WEST SUSSEX COUNTY COUNCIL CONSULTATION

TO:	Arun District Council FAO: Andrew Wood
FROM:	WSCC - Highways Authority
DATE:	28 June 2021
LOCATION:	Land adj Church Farm Barn Horsemere Green Lane Climping BN17 5QZ
SUBJECT:	CM/30/21/DOC Approval of details reserved by condition imposed under C/32/20/PL relating to conditions 3-schedule of materials & finishes, 4-car parking spaces, 5-covered & secure cycle parking spaces, 6-electric vehicle charging spaces, 7-landscape scheme & 8-detaisl of screen walls and/or fences.
DATE OF SITE VISIT:	n/a
RECOMMENDATION:	Advice
S106 CONTRIBUTION TOTAL:	n/a

Drawing Title
PROPOSED BUNGALOW - SITE
PLAN

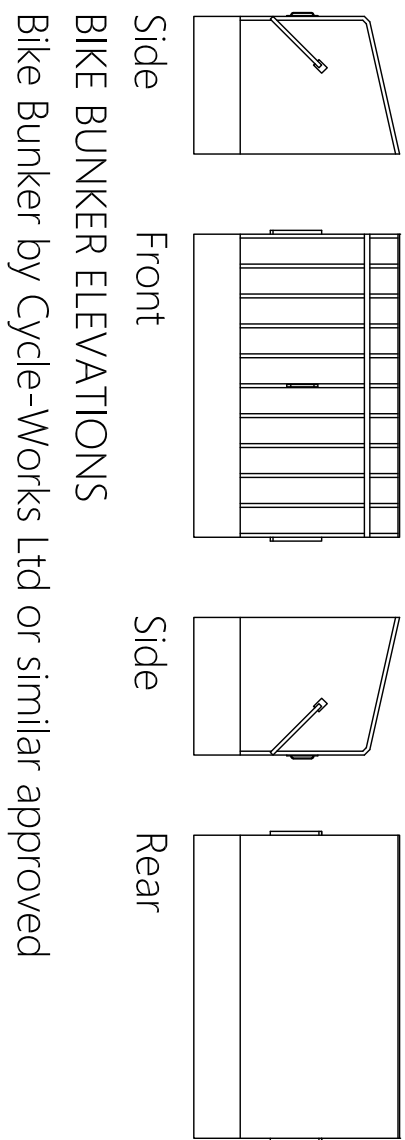
The proposed plans demonstrate three parking spaces for the proposed dwelling. This exceeds the minimum anticipated parking demand for the proposed dwelling, and therefore is considered acceptable.

The plans demonstrate that a secure and covered 'Bike Bunker' will be provided to the front of the site to provide storage for three bicycles. This is considered acceptable.

The proposed plans demonstrate that a single EV charging point will be provided to the site

frontage. The LHA would consider this acceptable, however it is noted that this does not meet the Arun District Council SPD requirement for 100% of spaces to be provided with EV charging facilities. The LPA are advised to consider whether the proposed provision is sufficient.

In conclusion, the LHA are satisfied that Conditions 4, 5 and 6 can be discharged. However, as above, the LPA are advised to consider whether the level of EV provision is sufficient for discharge of Condition 6.
